**Our Case Number: ABP-316828-23**

**Re:** Tallaght/Clondalkin to City Centre BusConnect Core Bus Corridor Scheme.  
Tallaght/Clondalkin to Dublin City.

# South Dublin County Council Submission on Bus Connects

Tallaght/Clondalkin to City Centre Core Bus  
Corridor Scheme.

Programme Title: BUSCONNECTS DUBLIN CORE BUS CORRIDORS INFRASTRUCTURE WORKS			
Drawing Title: TALLAGHT/CLONDALKIN TO CITY CENTRE CORE BUS CORRIDOR SCHEME STREET LIGHTING			
Drawing File Name: BCIDA-ACM-LHT_RL-0809_XX_00-DR-EO-0001	Sheet Number: 01 of 56	Status: A	Rev: M01

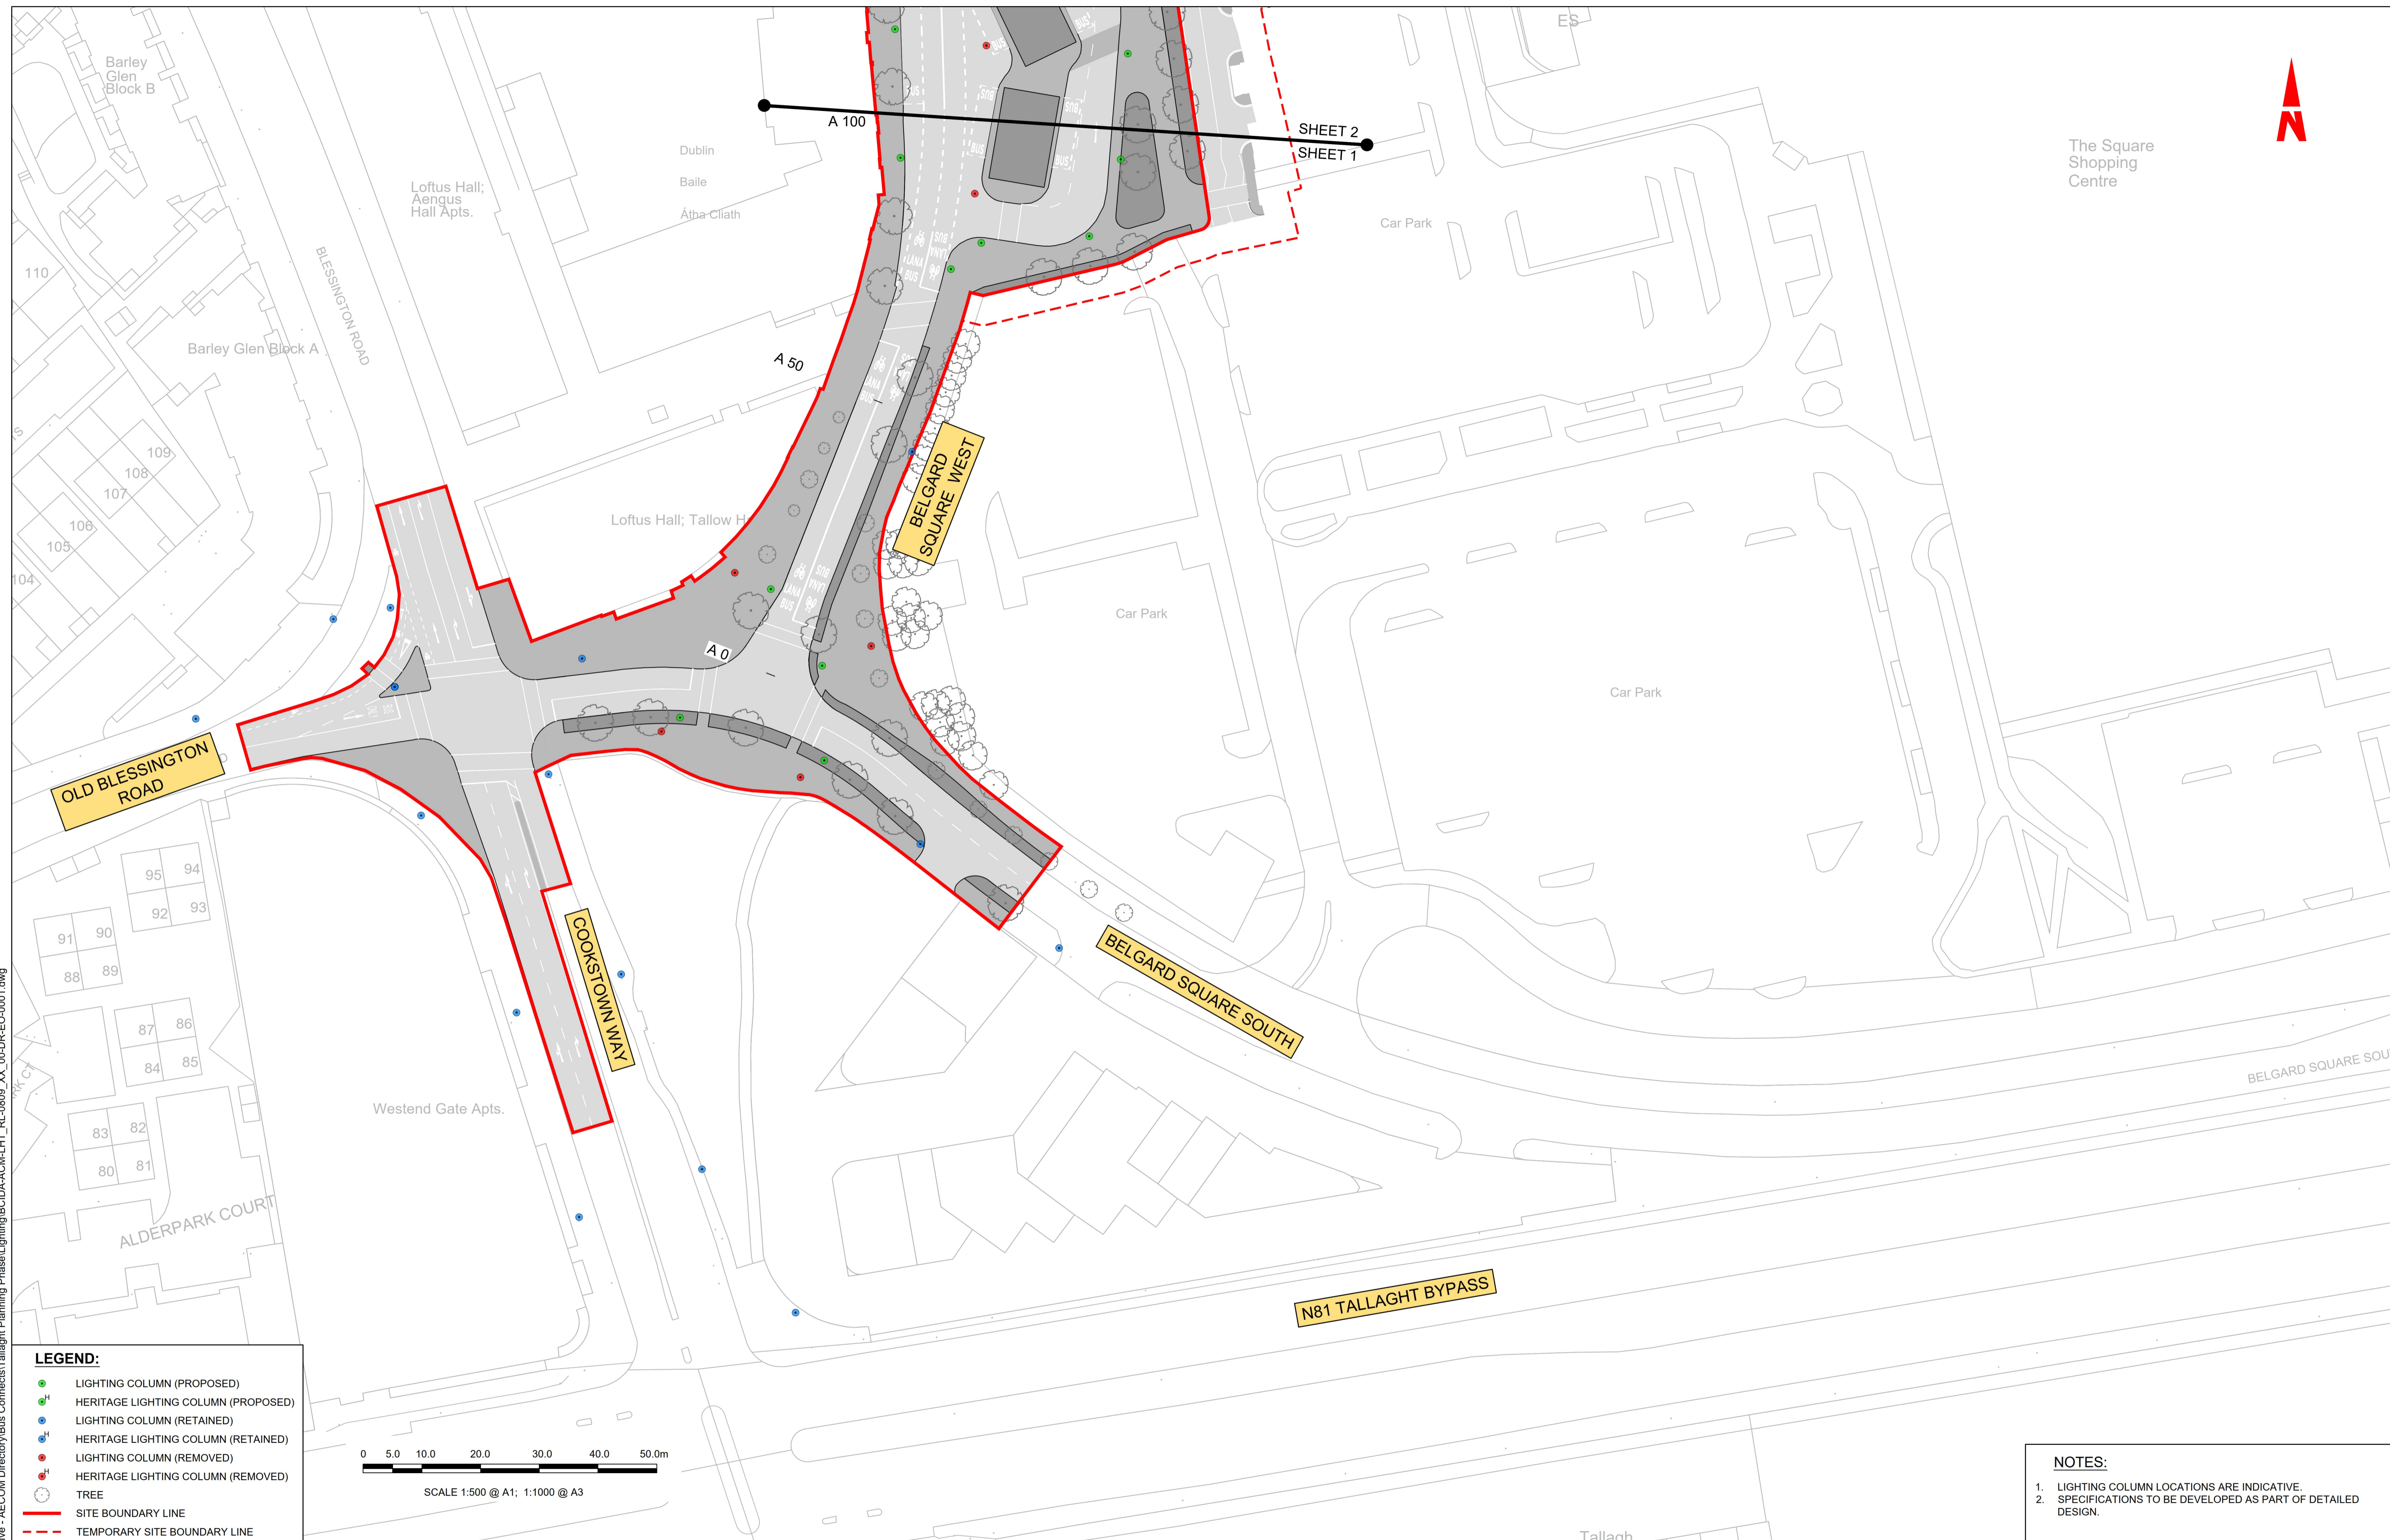
- (a) The NTA and SDCC worked closely on the design and layout of the proposed Bus Interchange at Belgard Square North and the interface with a new public plaza immediately adjacent the bus interchange. The Council is now progressing the delivery of this plaza and if this application is granted and progresses to construction it will be important that the NTA liaise with SDCC on tie ins and adjoining service connections to ensure the bus interchange and adjoining plaza are coordinated. This should be secured by planning condition. **(Sheets 1 and 2 of 56 on General Arrangement Drawings)**

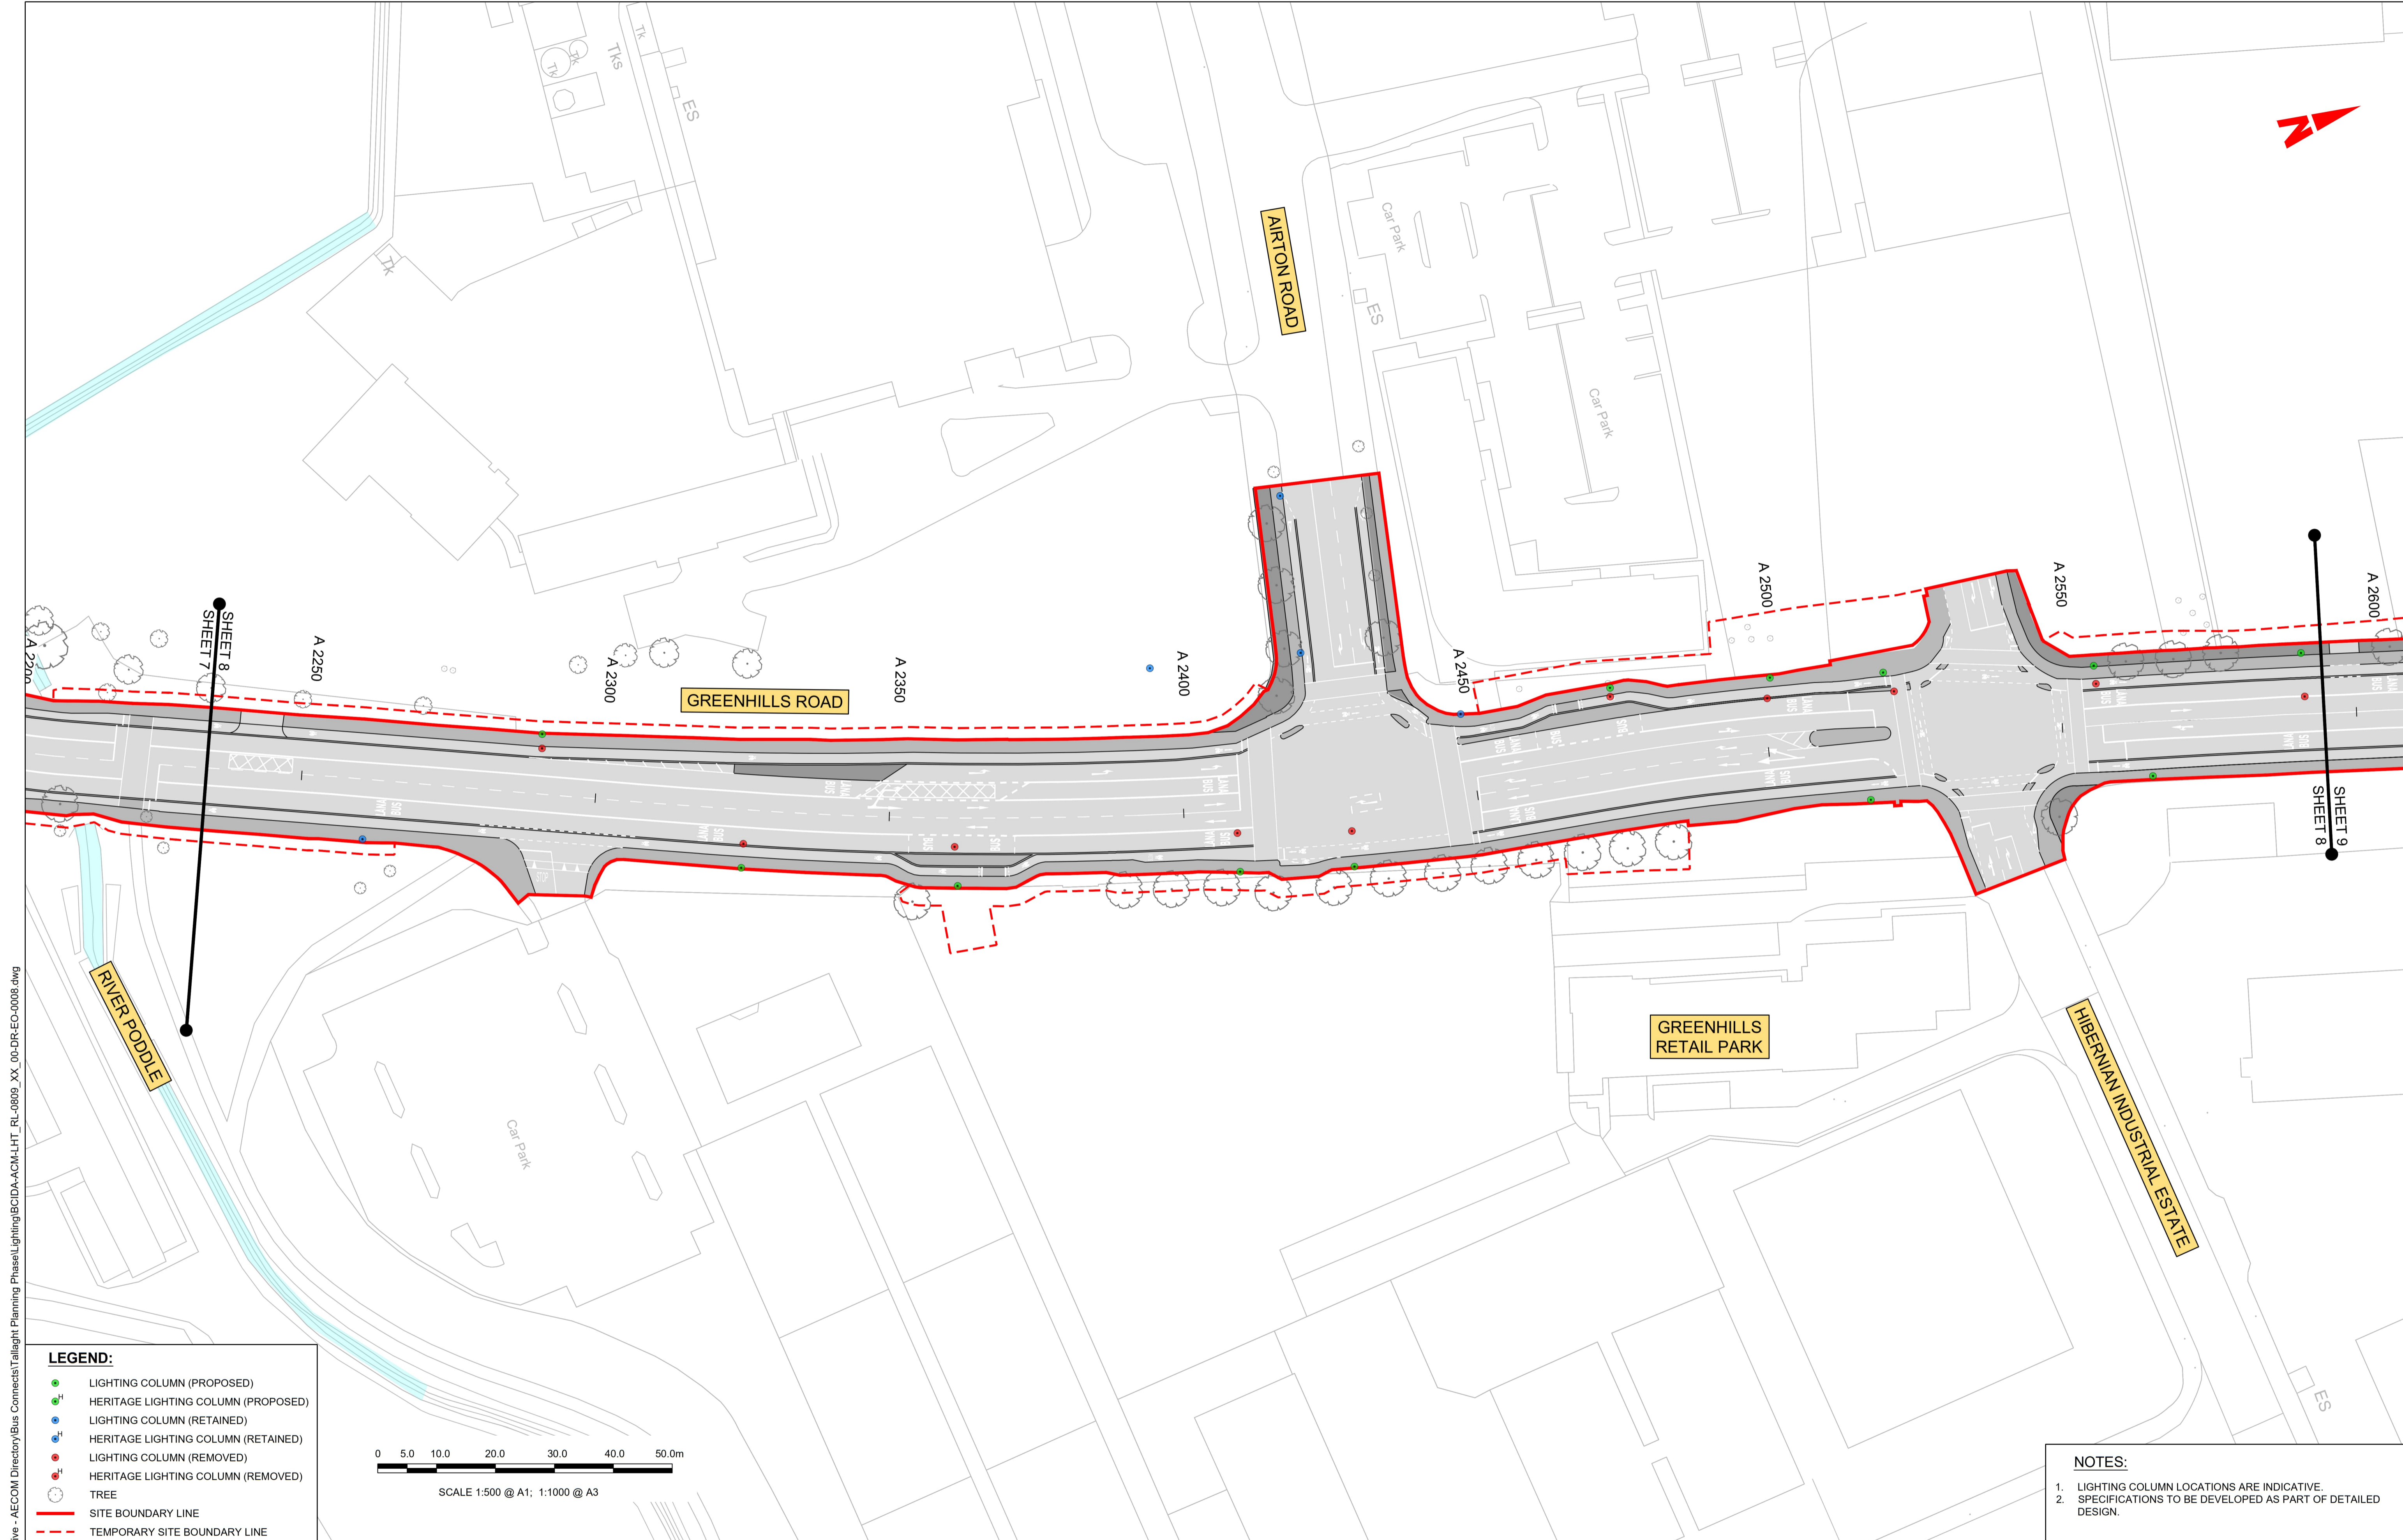
- (b) There are concerns about the location of the proposed temporary compound in Bancroft Park. Its location is believed to be too close to residential properties and the location has been a well-used amenity area for a long time. The other aspect in relation of the siting of the temporary compound is the dangers posed siting a compound with the associated HGV traffic in a busy residential area which has a high proportion of elderly people. The proximity of St. Marys National School to the proposed temporary site compound has also been raised by residents. The proposal to use this open space as a temporary site compound could create negative impacts on surrounding residential areas and the final design and layout, visual impact, hours of operation, traffic and noise should be secured by planning condition for agreement with the Local Authority. If permission is granted to use this space as a temporary work compound it will need to be reinstated to its original standard and that it will be handed back to the Council when the project is completed and that it is not kept as maintenance compound into the future. **(Sheet 6 of 56 on General Arrangement Drawings)**

- (c) The scheme will remove a recent Council delivered area of high-quality public realm at the junction of Old Greenhills Road and the Greenhills Road. The NTA should provide enhanced public realm along Old Greenhills Road up to the Tallaght Village area to mitigate this loss. To address this concern, the provision of enhanced public realm works along the Old Greenhills Road should be secured by planning condition in the event that planning permission is granted. **(Sheet 6 of 56 on General Arrangement Drawings)**
